**CITY OF PORTLAND, MAINE
DEVELOPMENT REVIEW APPLICATION
PLANNING DEPARTMENT PROCESSING FORM**

Pre fab. single family home

Hobart St, Portland Maine 04103

**CITY OF PORTLAND, MAINE
DEVELOPMENT REVIEW APPLICATION
PLANNING DEPARTMENT PROCESSING FORM
ADDENDUM**

SITE PLAN

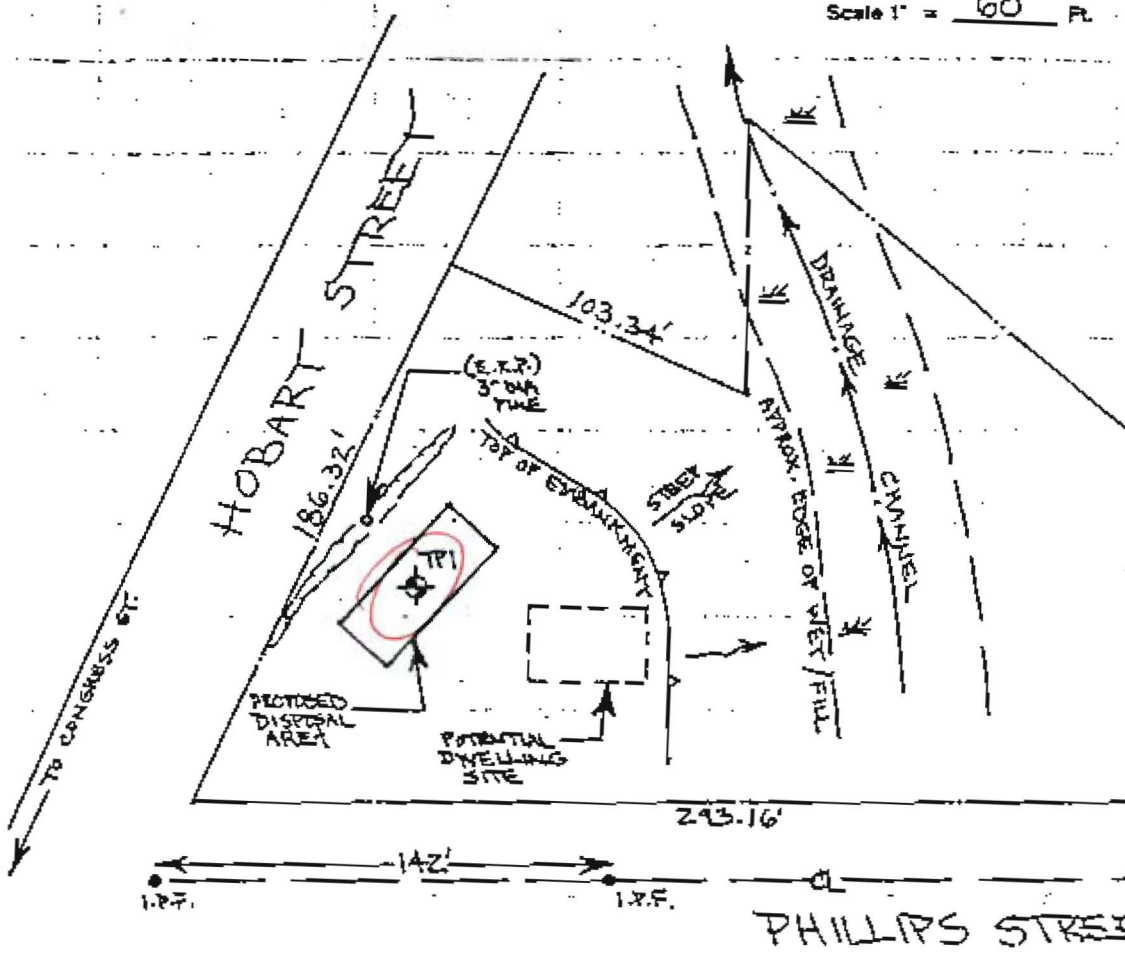
1. Plot plan does not show existing and proposed grade contours.
 2. Stream limits and or wetlands exist on site and a permit may be required (NRPA). Permit is not issued by city, but my MDEP.
 3. ** This lot may require the extension of Hobart Street.
 4. ** This lot will require a turnaround on Hobart Street.
 5. Utilities = water-sewer etc. shall be shown on the plot plan.
 6. Specific surface restoration and stabilization of slopes shall be shown on the plot plan. (erosion control mesh-rip rap - or retaining walls, etc.)
- (** The City contact for Item #3 and #4 would be Nancy Knauber. She can be reached at 874-8835.)

5. Show all utility connections: water, sanitary sewer, storm drain, electric, telephone, cable.
6. A sewer permit is required for your project. Please contact Carol Merritt at 874-8300, ext. 8828. The Wastewater and Drainage section of Public Works must be notified five (5) working days prior to sewer connection to schedule an inspector for your site. H H E 200

11. A drainage plan shall be submitted to and approved by Development Review Coordinator showing first floor elevation (FEE), sill elevation (SE), finish street/curb elevation, lot grading, existing and proposed contours, drainage patterns and paths, drainage swales, grades at or near abutting property lines, erosion control devices and locations and outlets for the drainage from the property.
